TRAILS AT ASPEN RIDGE

TRAFFIC SIGNAL & SIGNING PLANS

PCD File Number CDR-20-010

BRADLEY ROAD / LEGACY HILL DRIVE ROAD & SIGNAL PLANS		
TRAFFIC SIGNAL PLAN		
Subset: SG	Subset Sheets: 4 of 4	Sheet No: 4

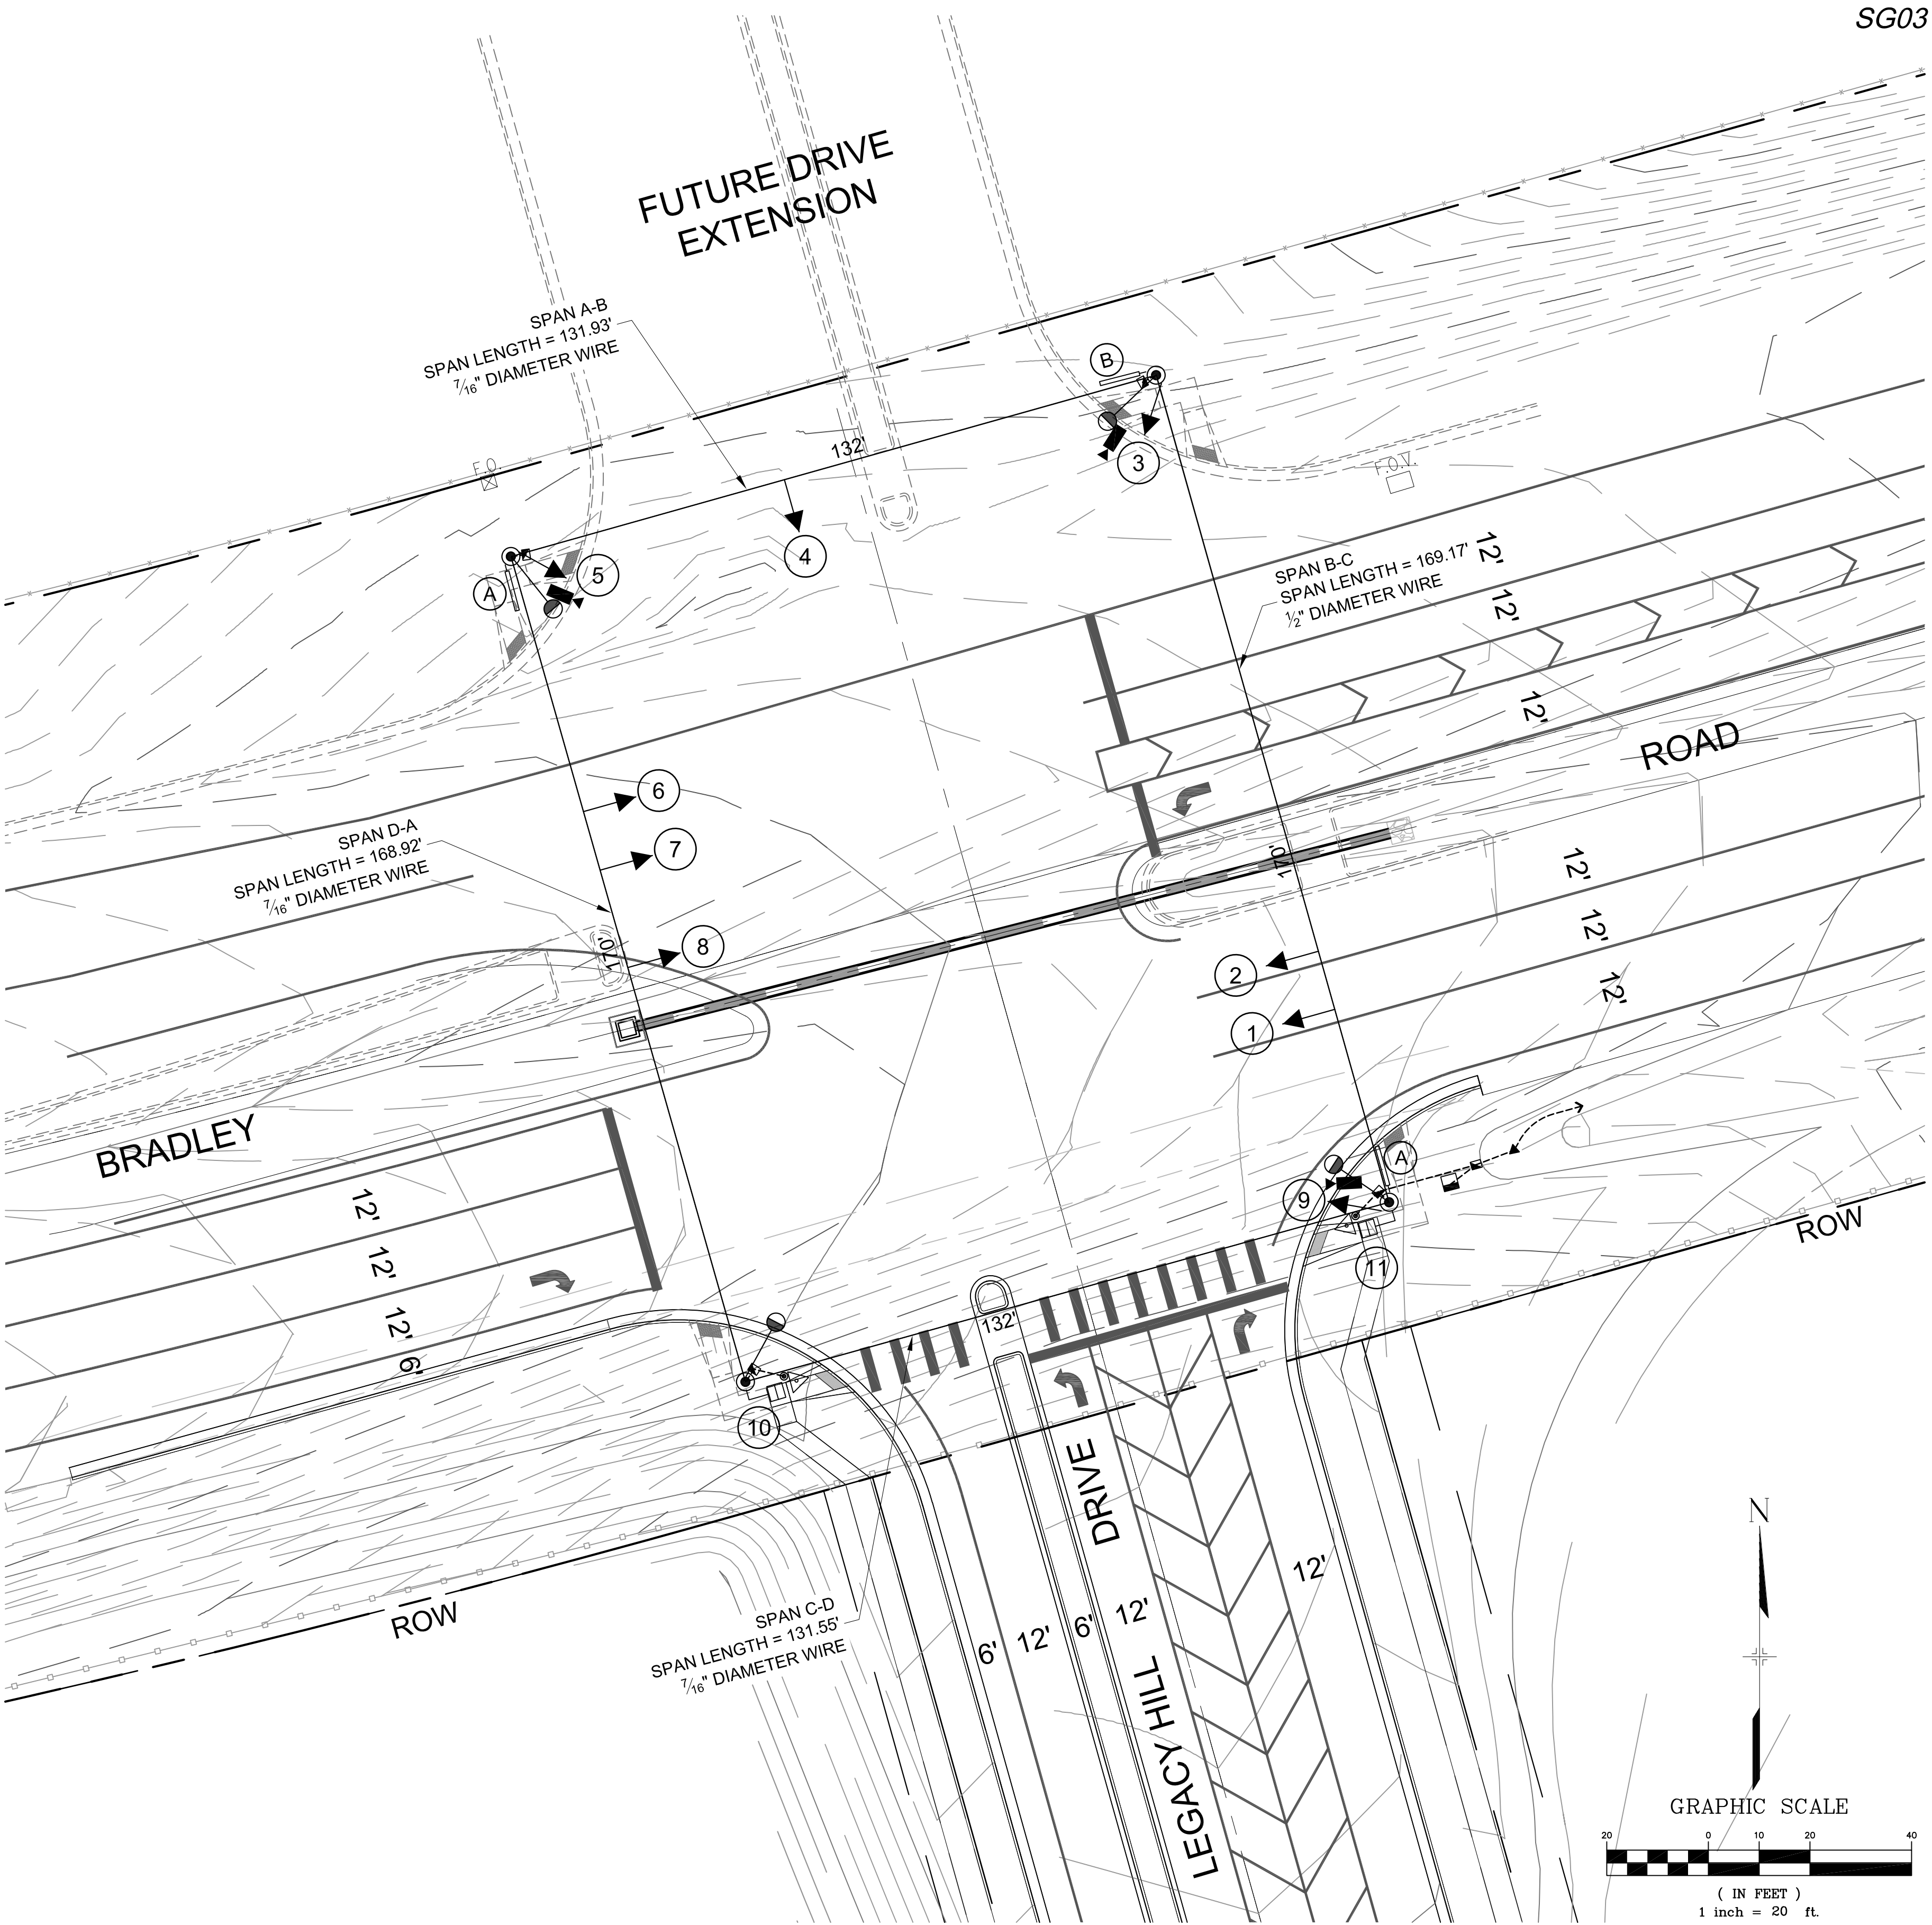
delete label

Add "No Pedestrian Crossing Signs pointing across Bradley Road"

Add "No Pedestrian Crossing Signs pointing across Bradley Road"

Delete City notes
